**From:** Graeme Thorpe  
**Sent:** 16 October 2013 16:09  
**To:** Jane Tucker  
**Subject:** FW: Hanson Garden Centre  
[Dated 16th October](#)

**From:** Lewis, Trevor [mailto:Trevor.Lewis@lancashire.gov.uk]  
**Sent:** 16 October 2013 12:57  
**To:** Graeme Thorpe  
**Cc:** Daniela Ripa; planning; Stevens, Neil; Crompton, Rachel  
**Subject:** RE: Hanson Garden Centre

AM PEAK TRIP DISTRIBUTION - Proposed NETT Development Vehicle Trips

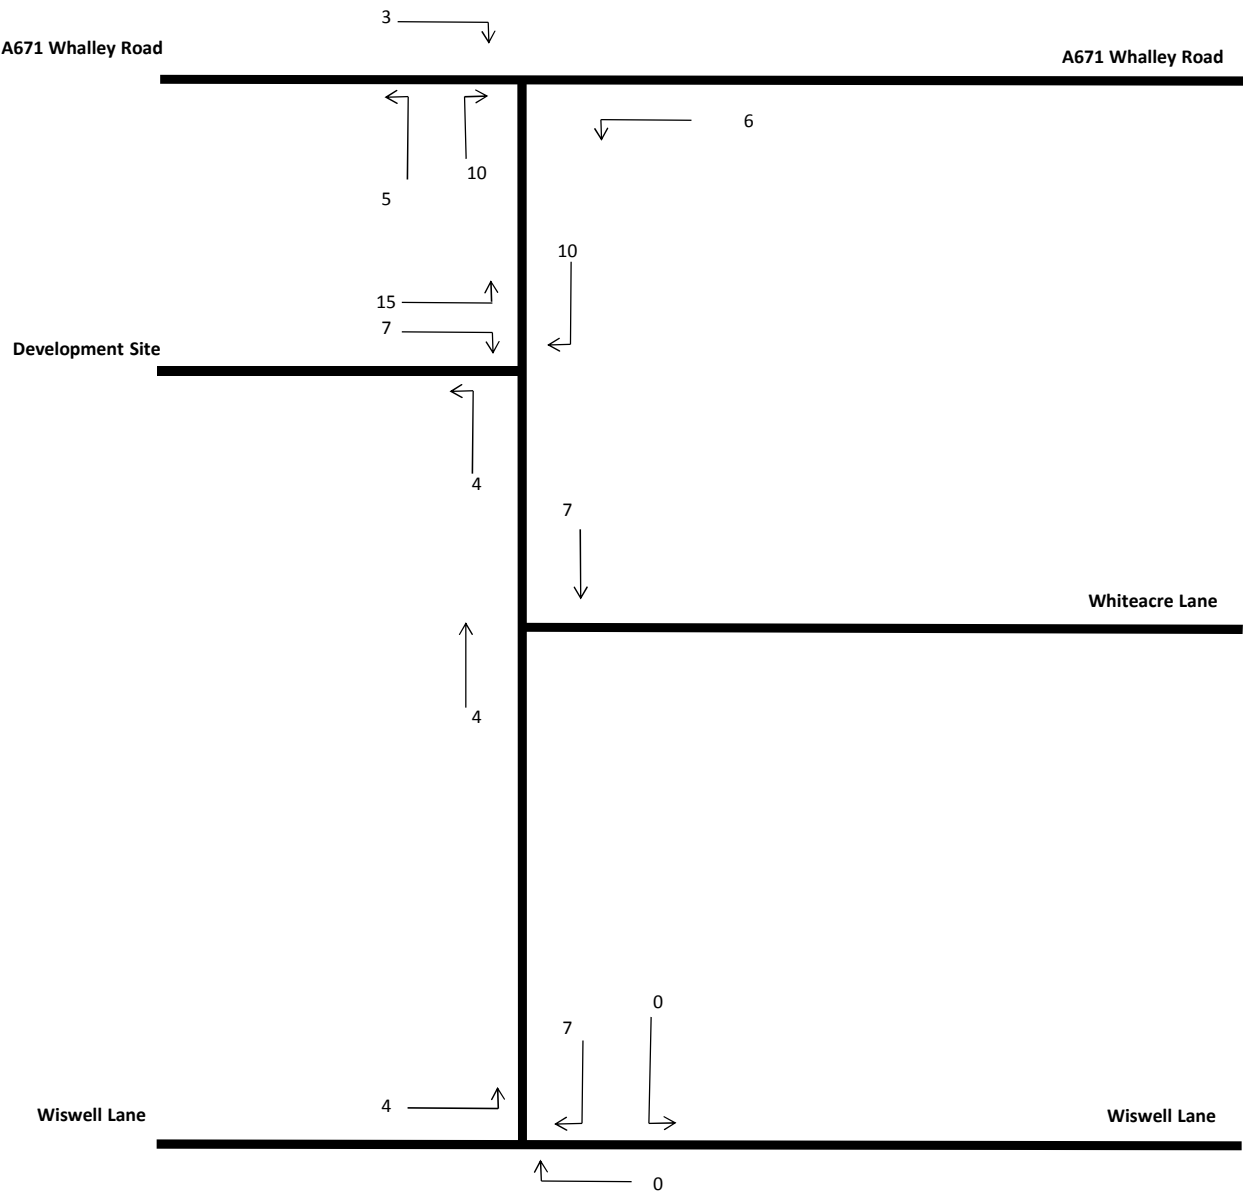
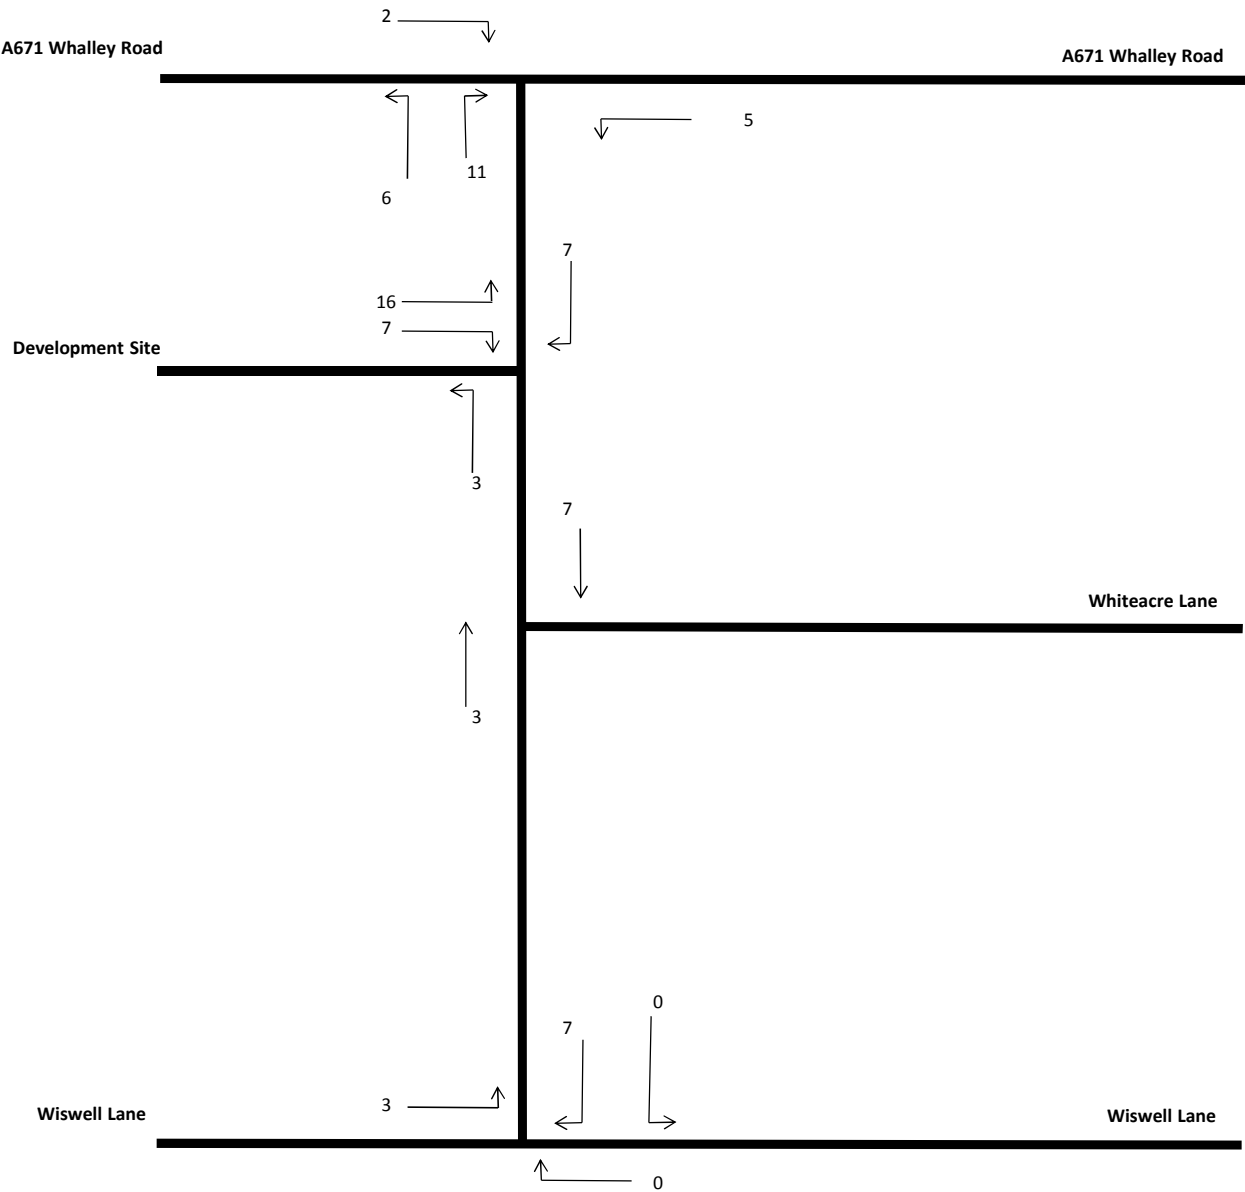
In the following table I have made a comparison between the Hanson's development and the Barrow Lands 190 dwelling development to show the amount of vehicular traffic turning right into A671 from Whalley Road. The vehicle numbers are those generated by the development only. For the Barrow Lands development the numbers are those predicted in 2019 without the link through Lawsonsteads. For Hanson's the numbers are taken from the transport assessment by Curtin's for the year of completion (it appears), being the nett development vehicle trips.

Development	No vehicles turning right Am peak hour	No vehicles turning right Pm peak hour
Barrow Lands 190 dwellings	20	7
Hansons 62 dwellings	11	-2

As you will note the amount of traffic contributing to the queues at the A59 roundabout is not in proportion to the number of dwellings. The reasons for this includes the way in which the distribution of traffic from these two sites was determined. Being further north and closer to A671, it was agreed that a greater proportion of the traffic generated by the Hanson's development would turn left out of the site towards A671.
